**SSD-76927247 – The Timberyards by RTL Co. (Project) - Objection**

**Re: Objection to SSD-76927247 - The Timberyards by RTL Co.  
Victoria Road, Sydenham Road, Farr Street and Mitchell Street, Marrickville**

### 1.0 Introduction

**2:00PM**

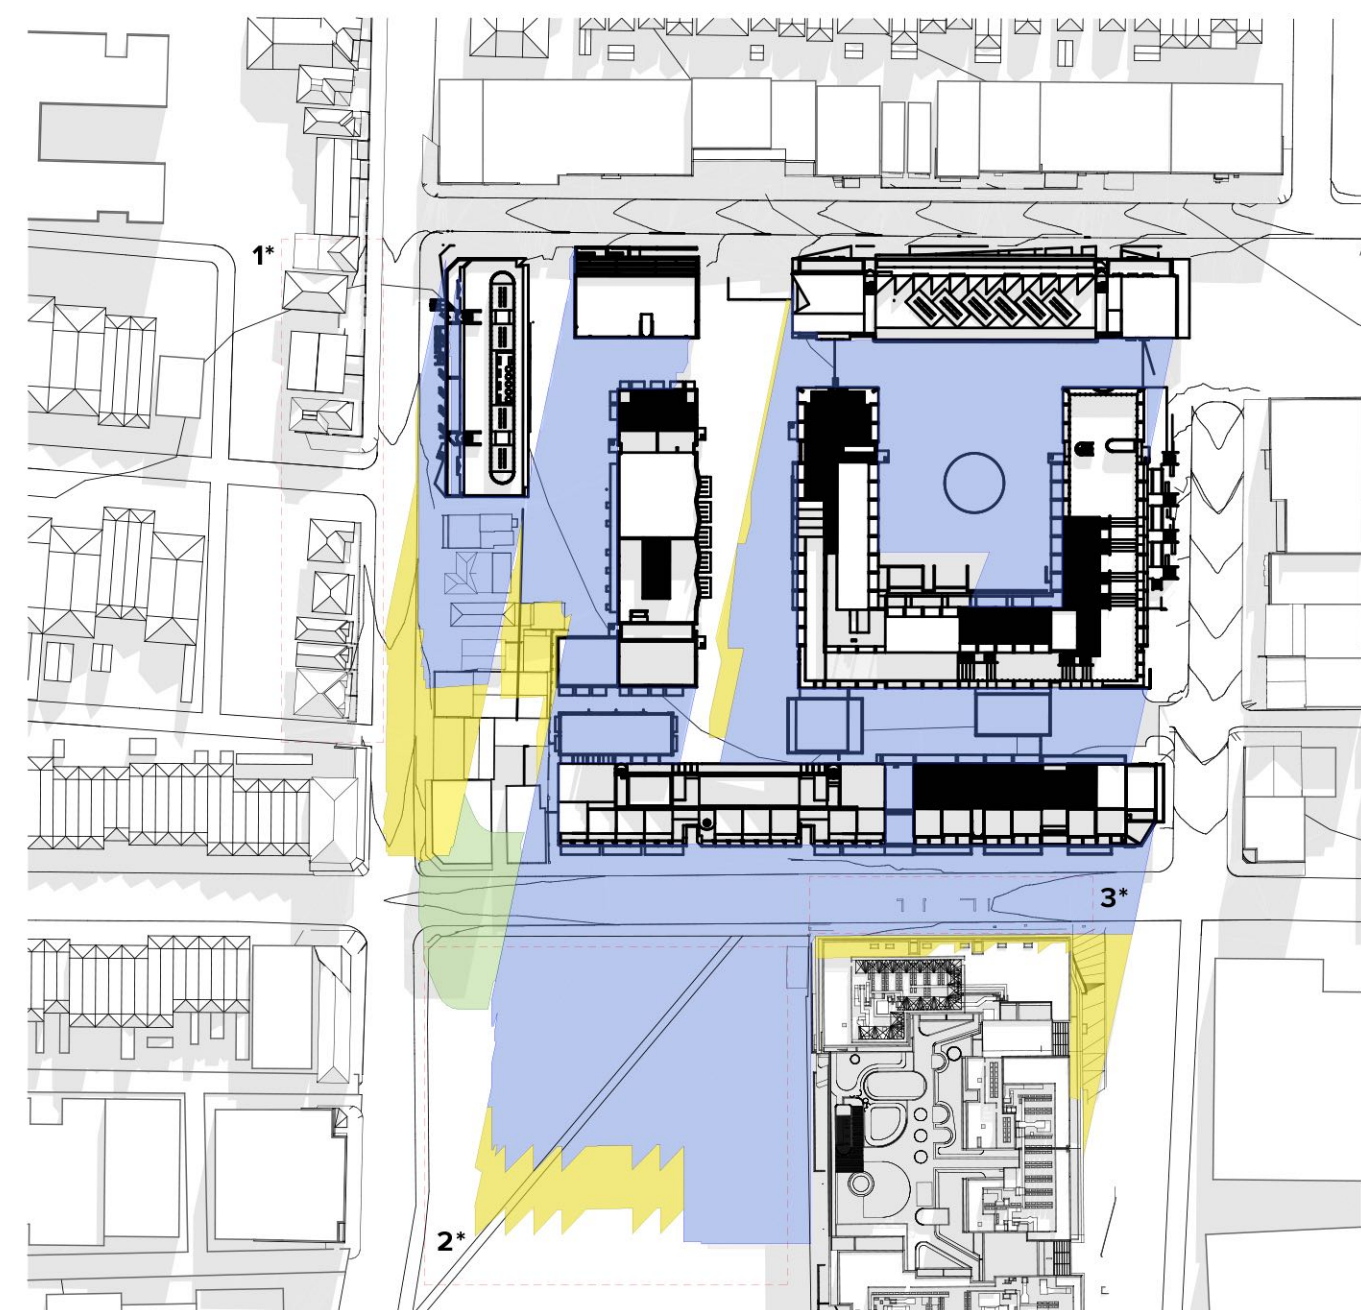
However, the information submitted with the DA does not include any analysis of the impact of overshadowing of the proposed development, especially Building E, on the northern façade of a future building on our Clients' Land or other land in the Corner Site.

Our assessment is that Building E will completely block sun to a future building on our Clients' Land between 9am and 2pm at midwinter and almost completely block direct solar access to any building on the Corner Site.

This can be seen from the extracts from the shadow diagrams from the DA documentation at **Figure 4** below.
